From: [Kelly Bacon \(CD\)](#)
To: [Holly Erdman](#)
Subject: FW: BL-22-00017 Rosenberry - Transmittal of Comments and Request for Information
Date: Wednesday, September 7, 2022 11:29:01 AM
Attachments: [Rosenberry.pdf](#)

From: Chris Cruse <chris@cruseandassoc.com>
Sent: Wednesday, September 7, 2022 11:27 AM
To: Kelly Bacon (CD) <kelly.bacon.cd@co.kittitas.wa.us>
Subject: RE: BL-22-00017 Rosenberry - Transmittal of Comments and Request for Information

Attached is a revised site plan for the Rosenberry application.

SITE PLAN PARCEL 3

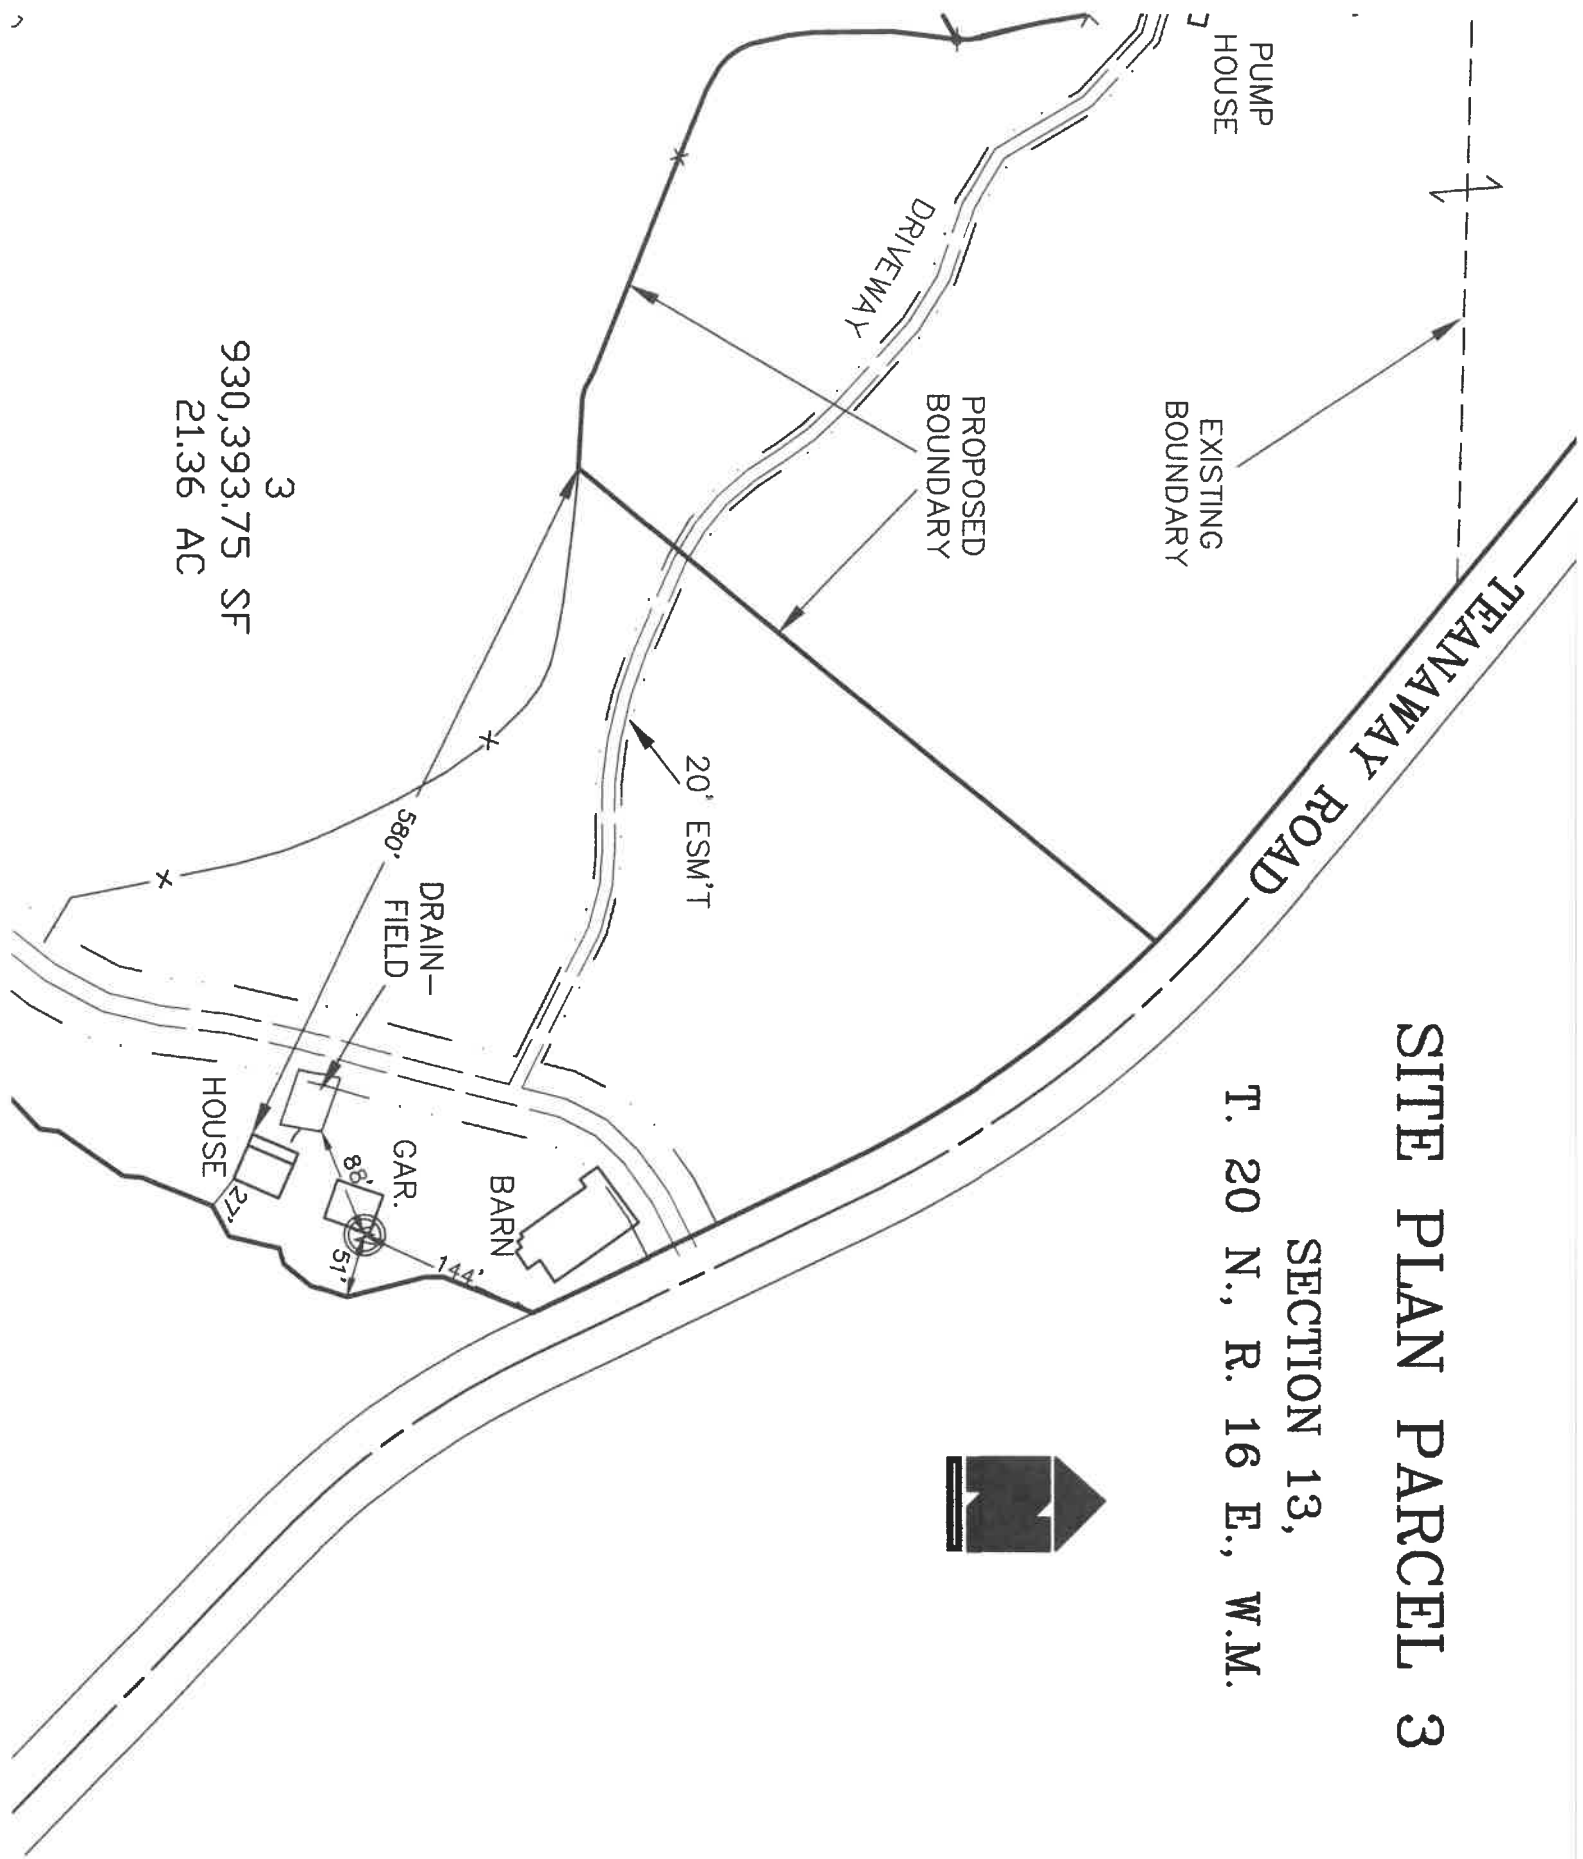
Attached please see Chris's response to PH request for information on the Rosenberry BLA. Please have any additional comments submitted by Monday, September 12, 2022 at 5pm. If additional time for review is necessary, please let me know.

I've added the setbacks for the septic tank and drainfield. Please note the 50' well setbacks are shown on the original submission.
